Planning Officer: Miss Z Toppin
Planning Application Ref: AW/247/20/T
Location: 36 Regis Avenue, Aldwick
Description of works: Re pollard to previous points 1No. Weeping willow tree
Reason given: Cyclical maintenance pruning
Comments on Application:

REF 1

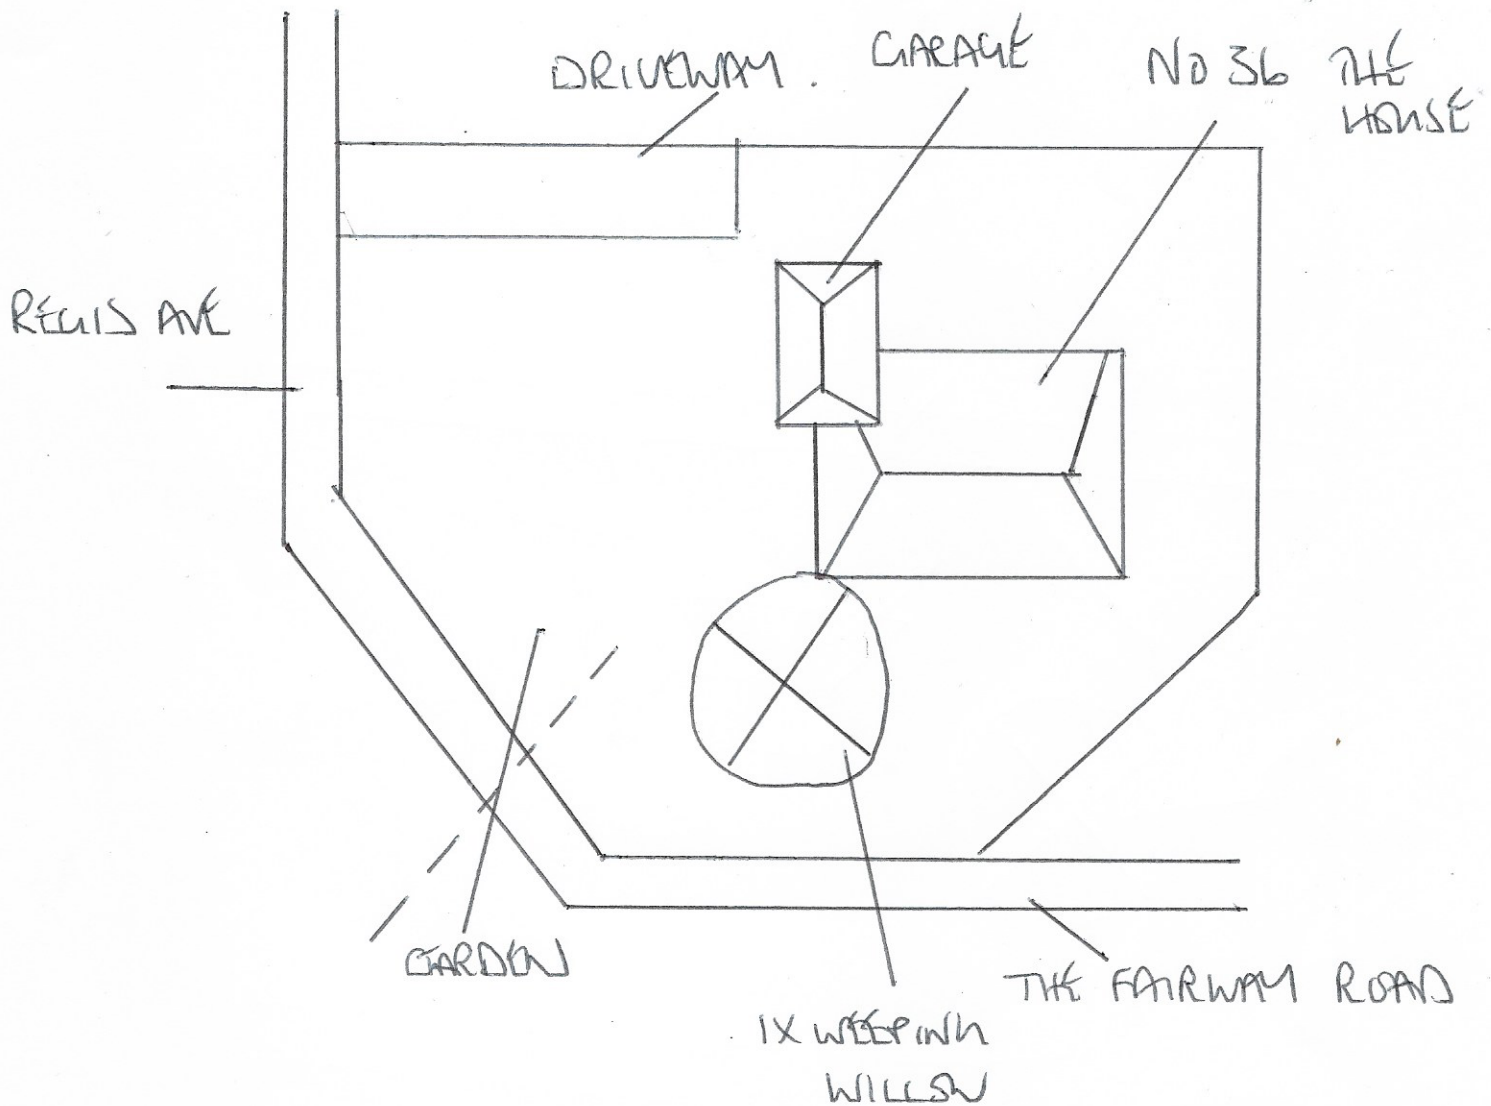
- Restricted view of tree, but condition of upper crown suggests it is in good physiological condition. It has been subject to heavy crown reduction work previously and has responded with vigour, typical for a healthy example of its type.
- Repeat operations such as now being asked for by the applicant will be necessary throughout the remaining lifespan of this tree, to achieve a reasonable degree of structural integrity appropriate for its location.
- The crown of this tree is periodically visible from surrounding properties and to users of the estate access road. The majority of this tree is obscured by boundary hedge.

- If the work is undertaken to a good standard and at the right time; then it is unlikely to have an adverse effect on its long-term vitality.

- I recommend **CONSENT** for this application, subject to the following condition:

- Part a) Where whole branches are to be removed and final cuts made close to the trunk or branch union they are to be made as shown in Figure 2 of BS3998:2010
- Part b) Where branches are to be shortened back the final cuts are to be made at the correct angle shown in BS3998:2010 and adjacent to a live bud or lateral.
- Part c) The removal of crown material which has developed since the last operation must be done sympathetically and with respect to established 'knuckles' so as not to extend beyond the point of origin.
